Our Case Number: ACP-324383-26

Re: Proposed IDA Belview Infrastructure Development
Belview, Slieverue, County Kilkenny

Road development Kilmurry

Title: **Proposed Access Road Layout Sheet 1 of 2**

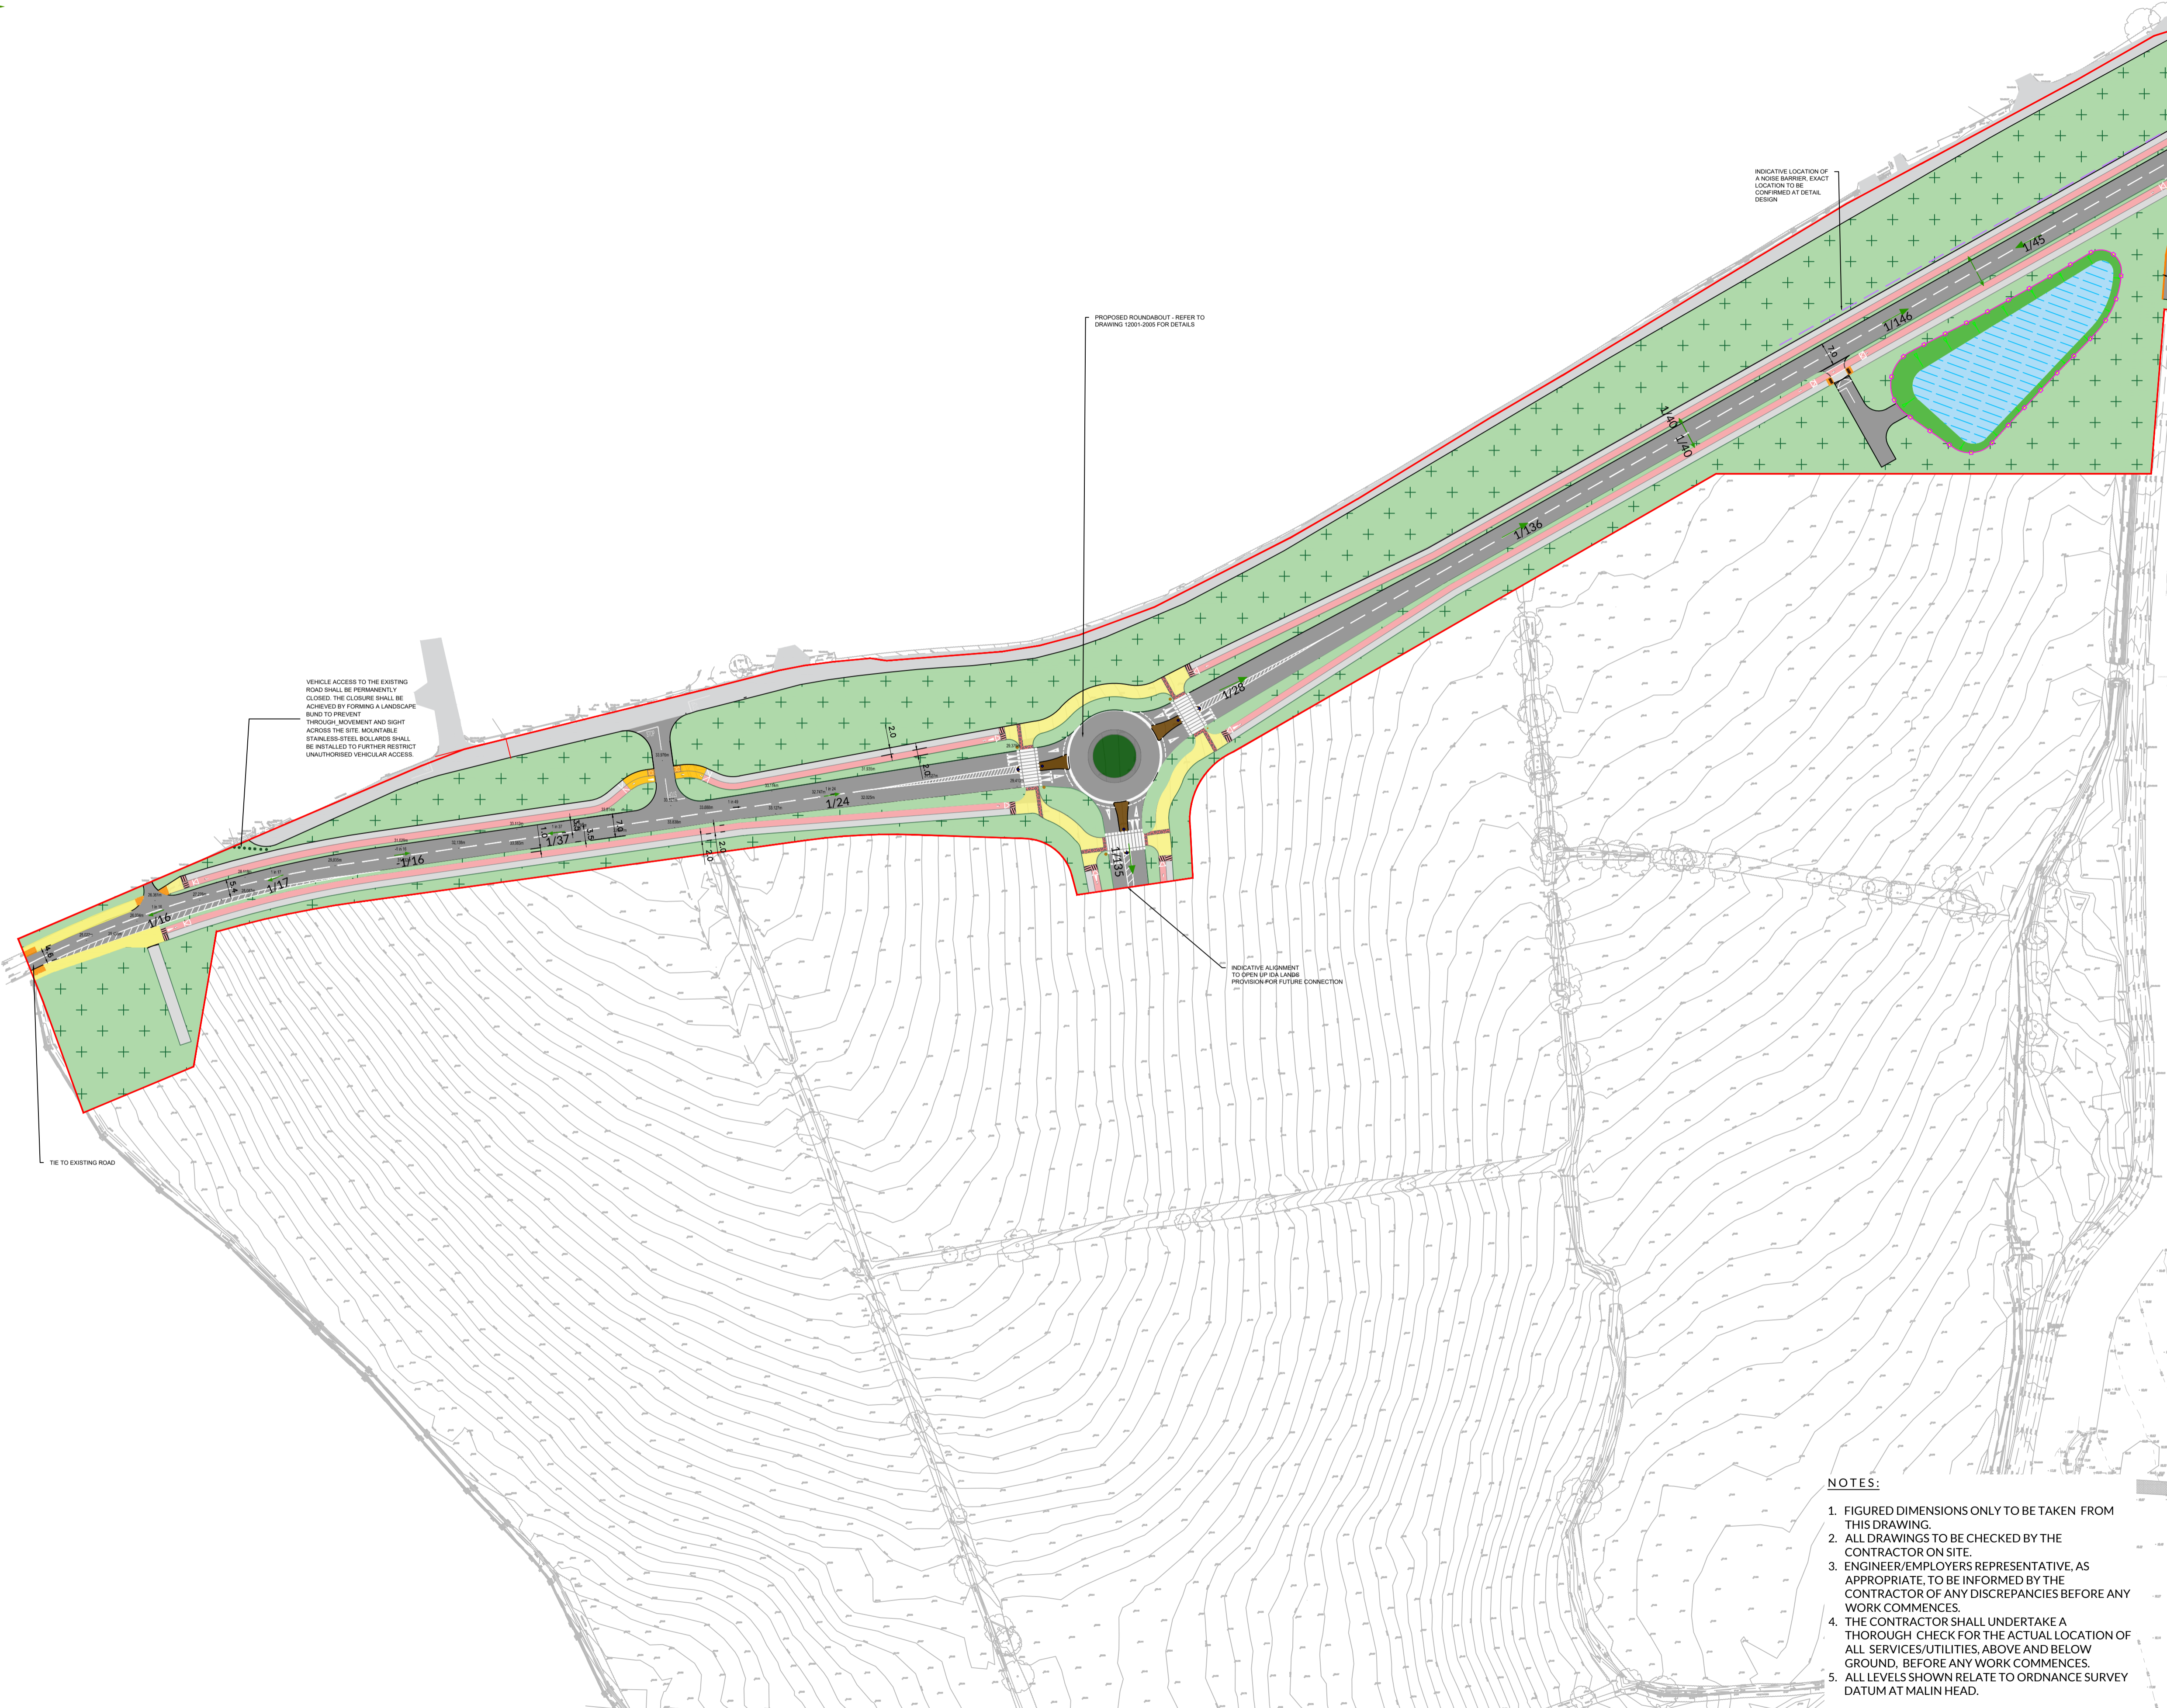
From what I can observe, it is your intention to effectively create a cul de sac roadway along the stretch of roadway where my parent live. It appears that this cul de sac will stop somewhere outside their residence. Surely it would make way more sense to include their residence in the cul de sac roadway. My reasons and concerns are as follows:

1. Safety concerns: Both my parents are elderly, being 86 and 83 years of age. They both currently drive and enjoy the independence that this brings. I fear for their safety however if they will be required to exit their gateway and turn on to a major road with a high volume of traffic. Likewise when they are returning home and entering their driveway. I am also concerned that their safety concerns may put them off driving altogether and hence restrict their independence and social contact.

2. Isolation concerns: My parents have happily resided in their home for the past 55 years and have been actively involved in fostering and developing a healthy community spirit over the years. They have always interacted socially with all of the nearby neighbours whom they would class as very good friends and not mere acquaintances. If the road was to be closed off outside of their home and they were excluded from the cul de sac design currently being proposed, I would fear for their sense of isolation at being cut off from the small local community of which they have been at the heart of for many years. Surely it would make way more sense to include all houses on this small stretch of roadway in the new plans rather than segregating my parents home from the community.

3. Noise concerns: It appears that the new plans will not make much of an allowance for any buffering of noise and pollutants by way of trees or distance, as is the case further along the roadway. My parents house is the last house along the stretch of roadway being impacted by the development. The new road will join the existing roadway outside my parents house. It would be way better if the new road was set a little further back from the existing roadway so as to alleviate these concerns, perhaps leaving the existing hedgerow in place to create a buffer along with additional planting.
